WELWYN HATFIELD COUNCIL – DEVELOPMENT CONTROL
DELEGATED REPORT

APPLICATION No:	S6/2008/574/LB
------------------------	-----------------------

The application seeks permission to remove the existing free standing signs and replace them with three free standing cylindrical signs. One would be placed at each access point and have dimensions of 3.5m in height by 1.5m in width. The signs would be internally illuminated and red and grey in colour.

| Address:  | ST. ALBANS ROAD WEST, HATFIELD |       |         |                 | Sign: 3          |

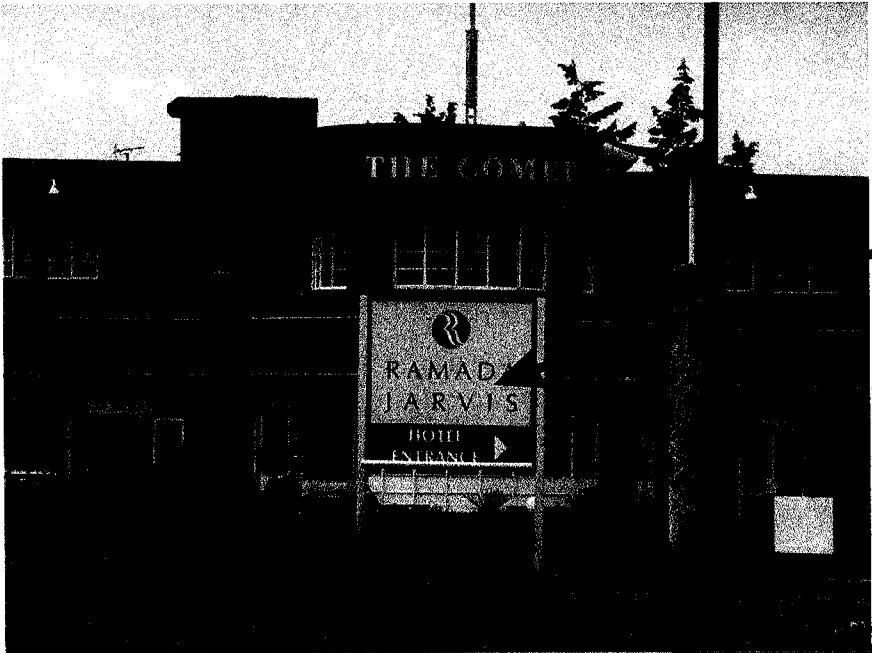
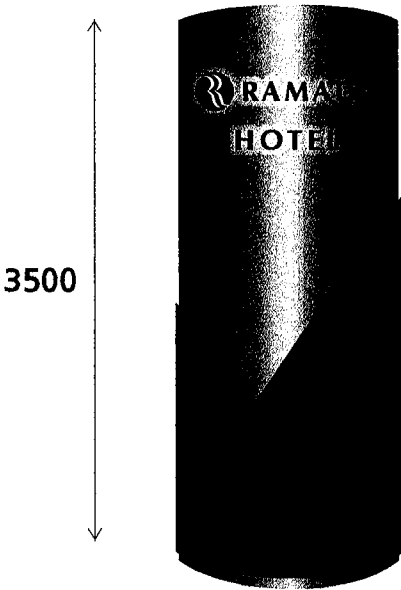
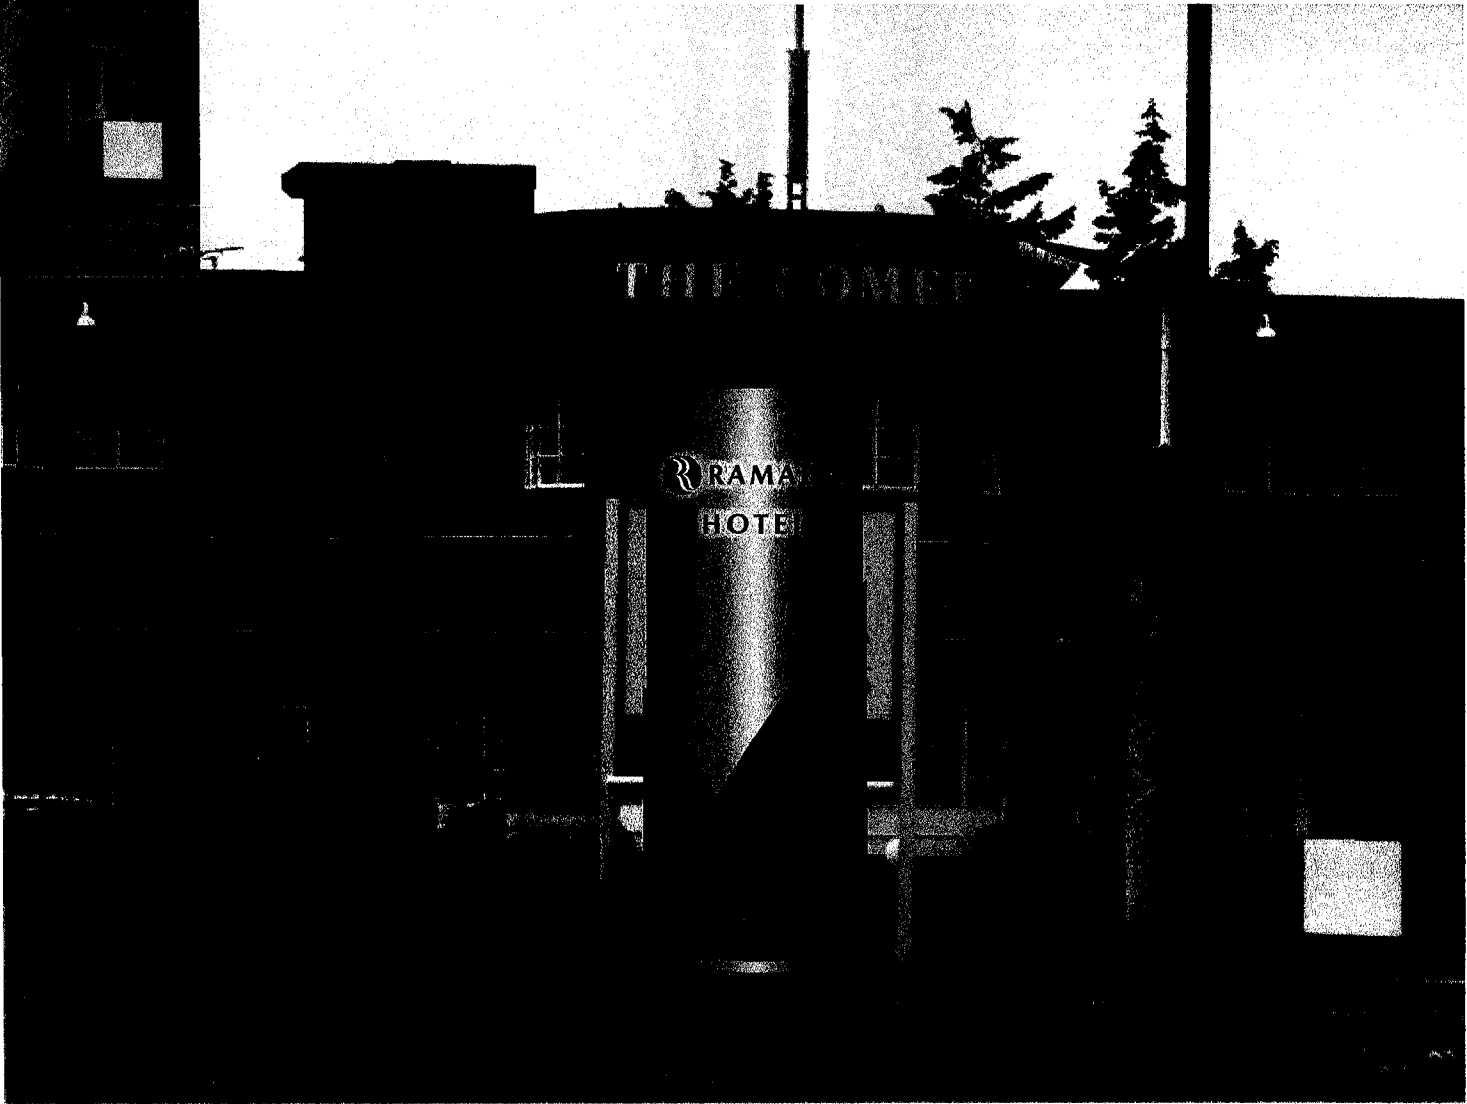
The signs would represent an obtrusive form of development that completely detracts from the character of the Listed building and its setting. The choice of red and grey is harsh and dominant and combined with the height at 3.5 metres and width at 1.5 metres, it is considered that the signs are out of scale with the Listed building.

- 1)The proposed free standing signs, by virtue of their location, number, design and size would have a detrimental impact on the character and appearance of the Listed Building and its setting, which would both dominate and detract from the architectural qualities of the building and the visual amenity of the street scene. This is contrary to PPG15 and Policies D1 and D2 of the Welwyn Hatfield District Plan 2005 and material contained within the Supplementary Design Guidance.
